From: Claire Potts
Sent: 18 March 2019 11:16
To: Planning.Responses
Subject: FW: Saltbox - BE/135/18/PL

Please see the consultation response from Environmental Health regarding the Salt Box application (BE/135/18/PL).

From: Fiona Fitzgerald
Sent: 11 March 2019 10:25
To: Planning.Responses
Cc: Michael Eastham
Subject: Saltbox - BE/135/18/PL

In response to the Sharps Redmore Acoustic report for Saltbox, Bognor Regis, Sussex, Project Number: 1818341, dated 6th December 2018 Environmental Health have responded with respect to each unit as this follows the set-up of the acoustic report:

A: With Acoustic Barrier Daytime L_{Aeq}

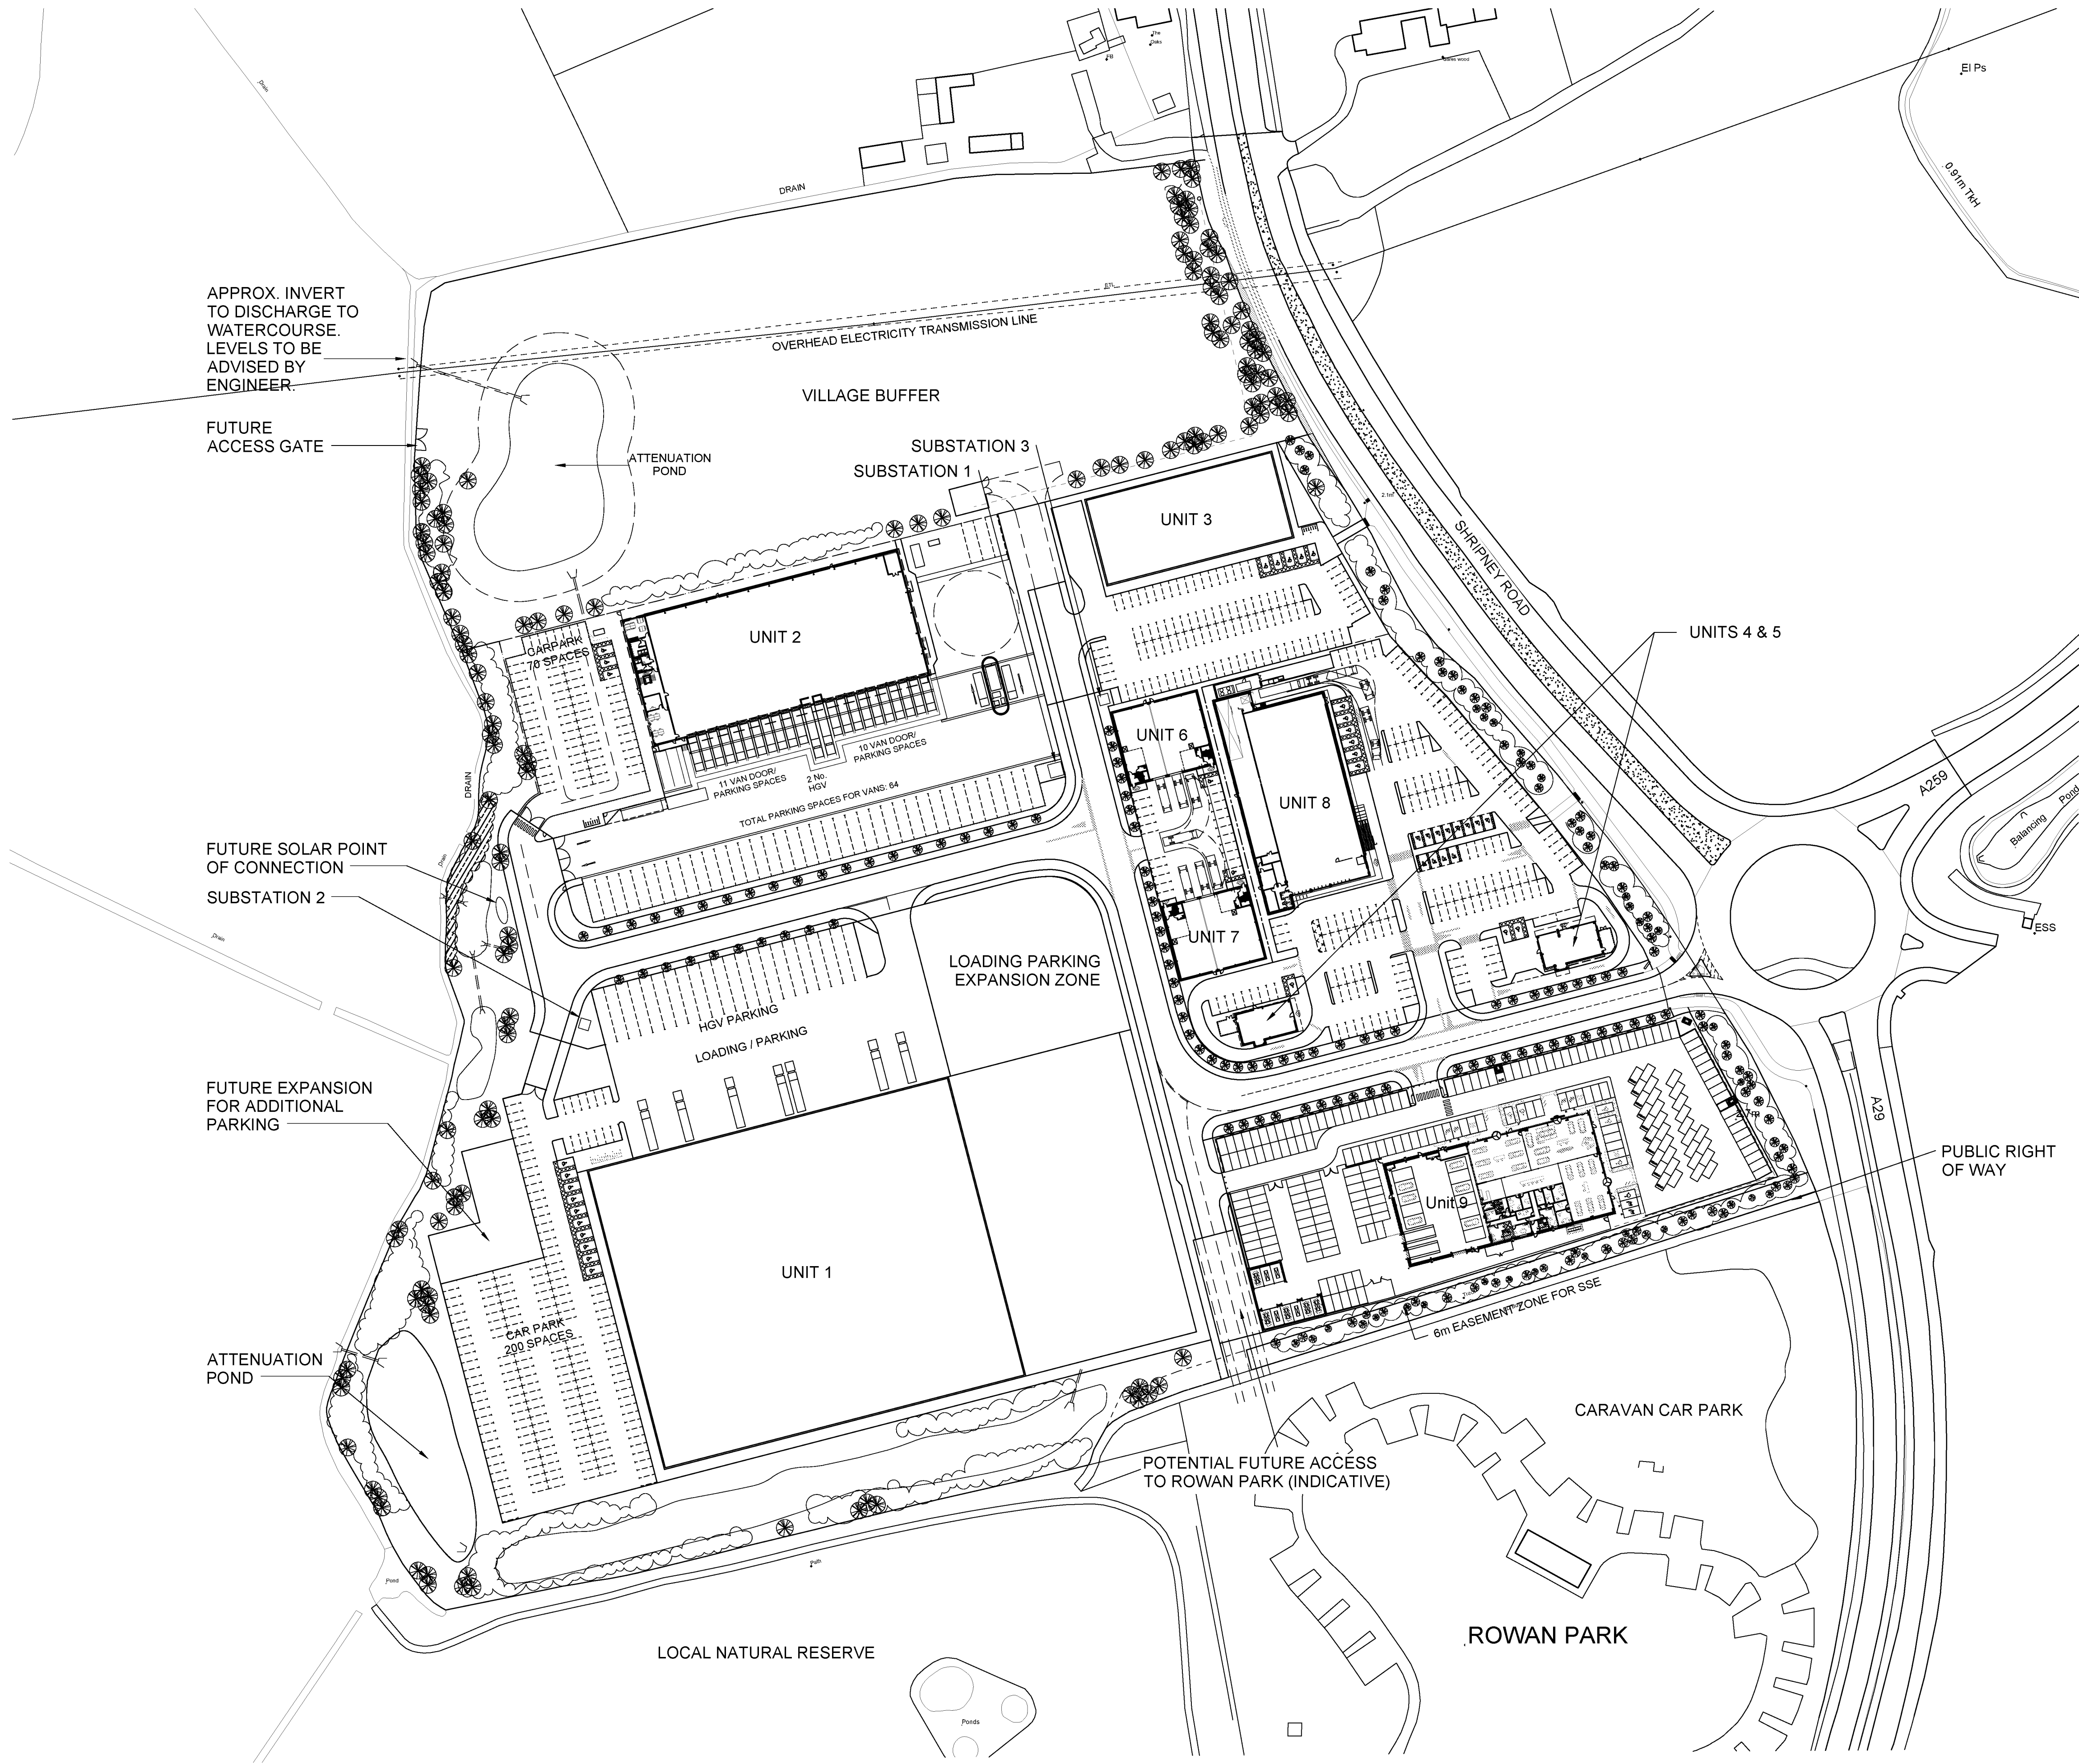
14. Please could the applicant provide a Soundplan map showing 'with acoustic barrier Night-time LAeq' as only the daytime one is provided. Our consultants consider this is not applicable as night time LA Max is considered robust in terms of sleep disturbance.
15. In Appendix A the LAMax with Acoustic Barrier map does not detail whether this is daytime or nighttime. Please could this be clarified? Night time.
16. It would appear from Appendix A daytime that the LAMax levels will vary from 50-53dB (southern part of the caravan site) to 53-56dB (northern part of the caravan site). This therefore varies from moderate annoyance to above serious annoyance under the WHO guidelines. Part of the caravan site also falls into the 60-62dB LAMax contour, so again, above the WHO guidelines.

WHO doesn't consider LAMax parameter in terms of annoyance. The models show 24/7 use. The restrictions proposed in the conditions will bring these levels down accordingly.
